July 21, 2021

**RE: Letter of Intent for Les Schwab Tire Center  
Special Use Permit Application  
PCD File No. PPR-21-023**

Les Schwab Tire Center is applying for Special User Permit (SUP) for a new tire center.

SPECIAL USE PERMIT SITE PLAN

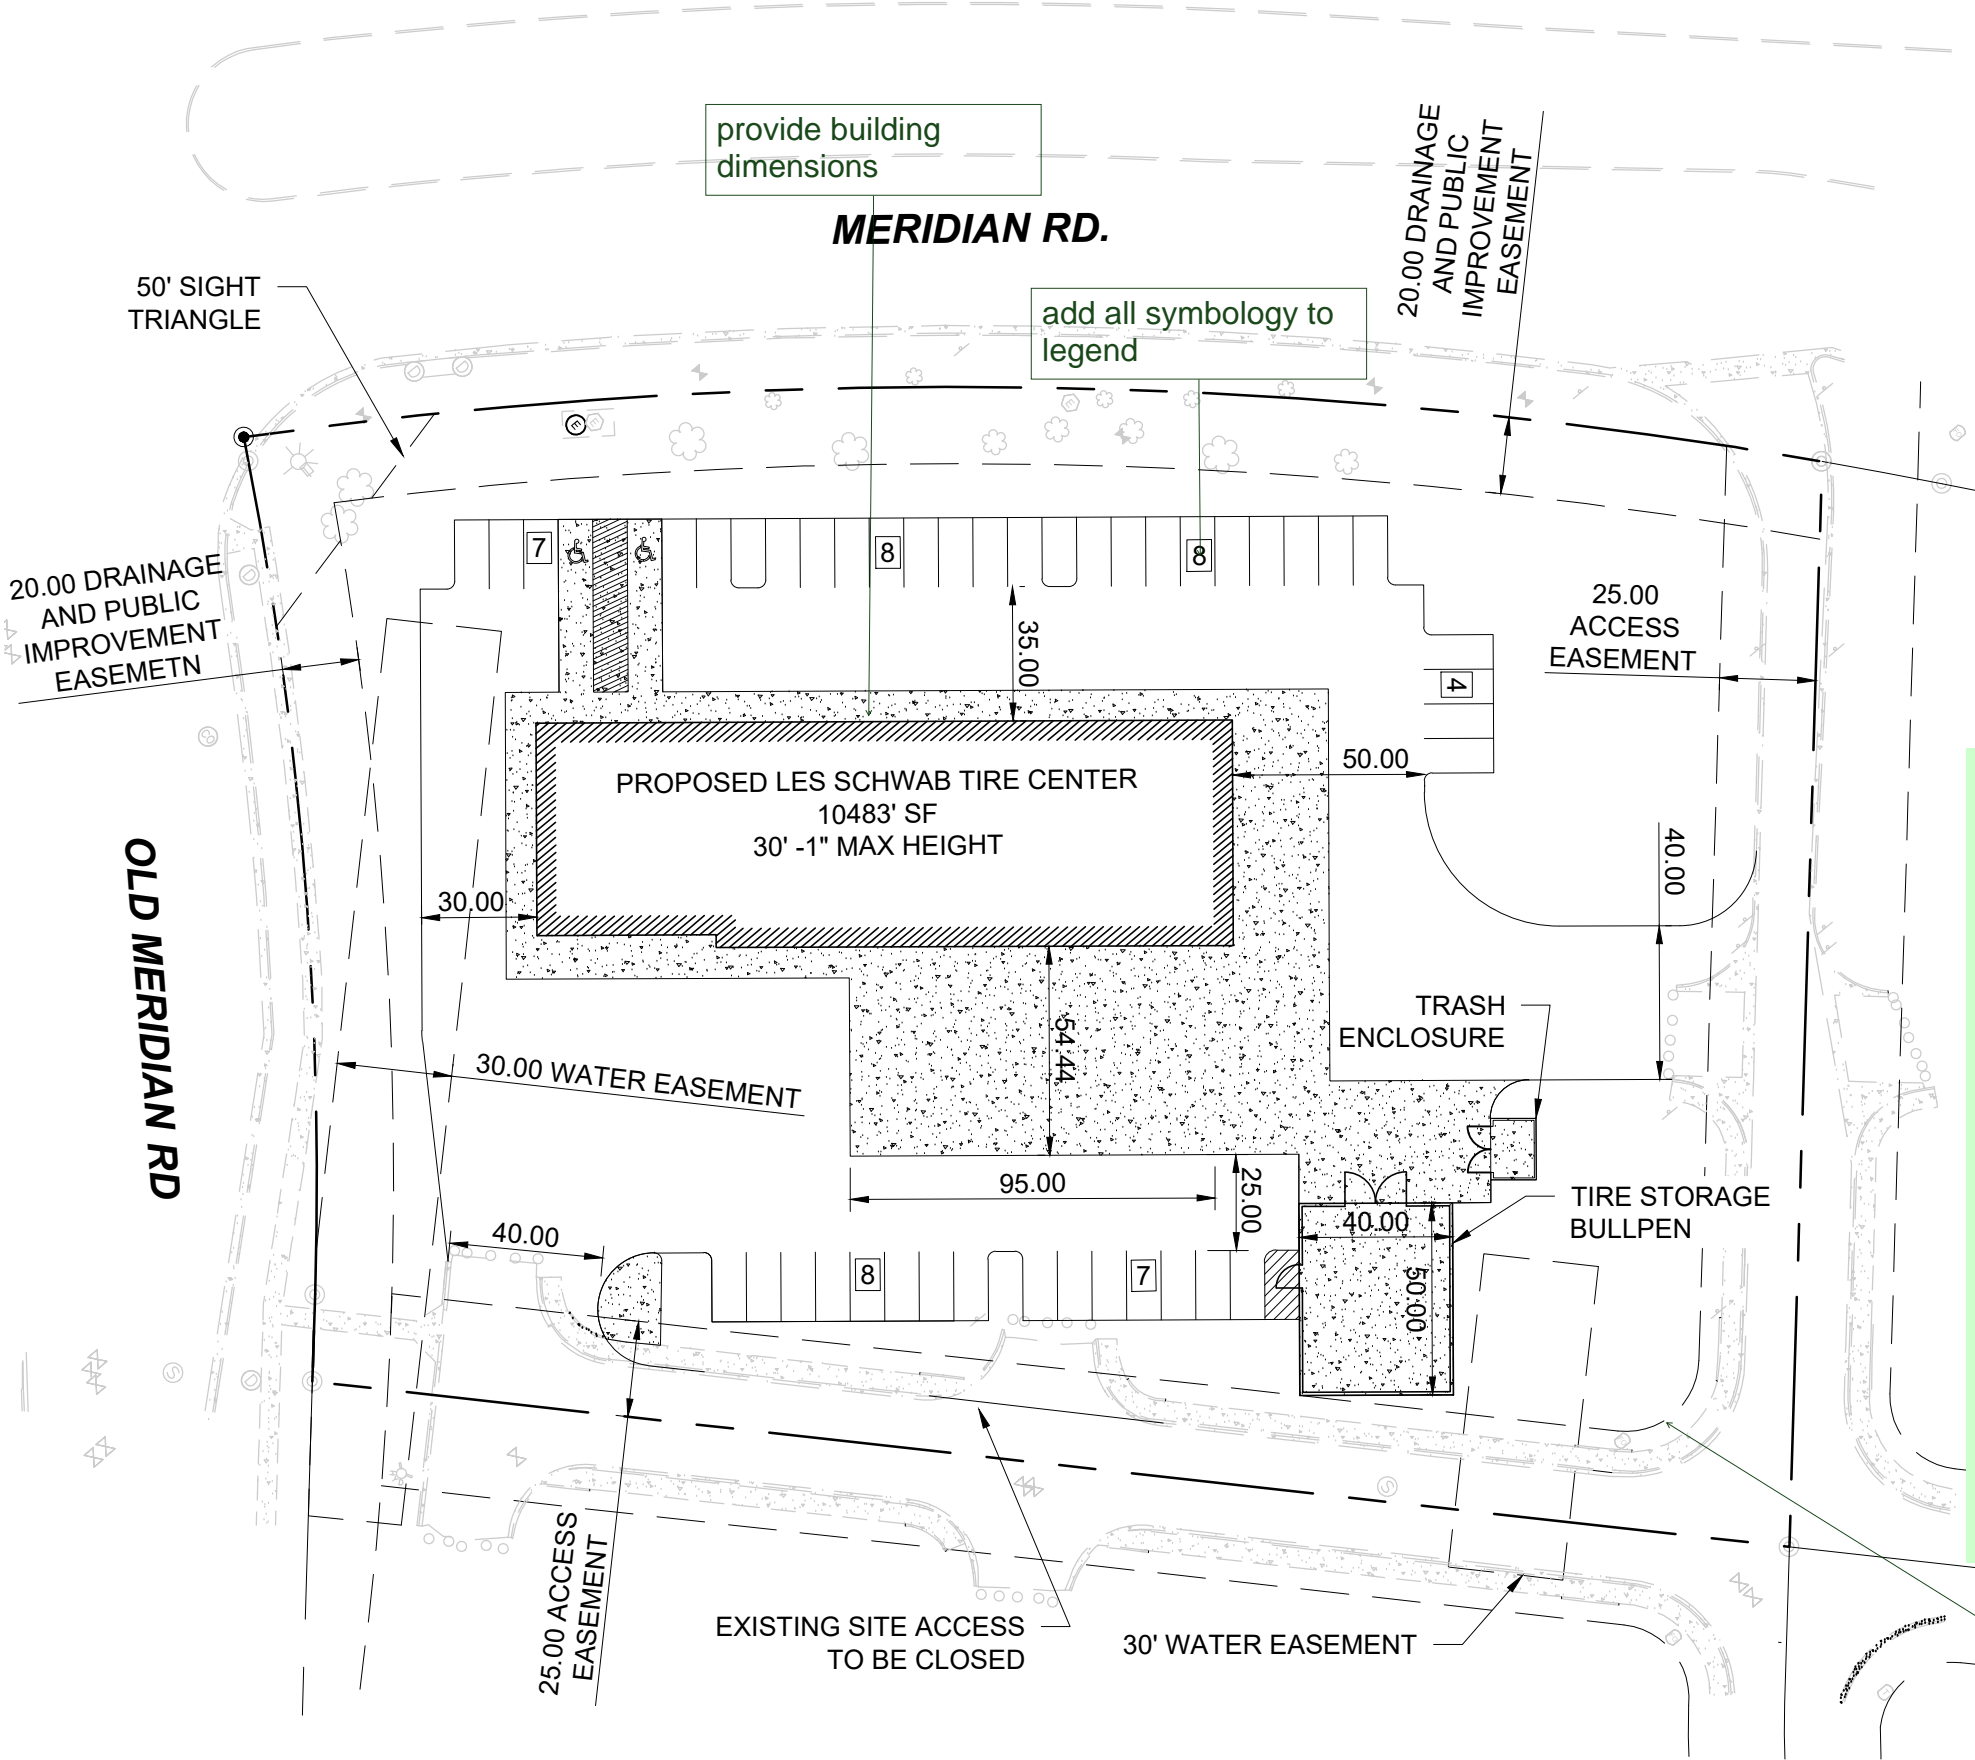
1. Dimensions of all property lines
2. The building footprint for all structures depicted and labeled to include the proposed use(s), floor area, and height. The setbacks of all building footprints dimensioned from all property lines.
3. Location and width of all sidewalks
4. Location and height of all fences, walls, or berms
5. Location and dimensions of all existing and proposed signs
6. Traffic circulation including all points of ingress/egress into the property

7. The layout and location of all off-street parking, loading and other vehicular use areas
8. Location of all ADA parking spaces, ramps, pathways, and signs

9. Location, height and intensity of all outdoor illumination
10. Location of existing and proposed water and wastewater infrastructure, including well(s) and septic system(s)

11. Location of all no-build areas, floodplain(s), and drainage facilities
12. Location and screening of all dumpster(s) and loading dock areas
13. Standard details of parking (compact, ADA, standard), ADA ramps, driveways, and signs

14. Location of all existing and proposed utility lines and associated infrastructure
15. Existing/proposed land use, parcel size, and zoning
16. Percent of open space, landscaping, and lot coverage

17. Density and number of dwelling units
18. Computation identifying the required parking and the provided parking
19. Add all abbreviation to legend
20. Please add the 25 foot cross access and utility easement

21. Please add "PCD File No. AL-21-005"

**Response: Resubmittal includes more detailed SDP plan set that includes the items listed above.**
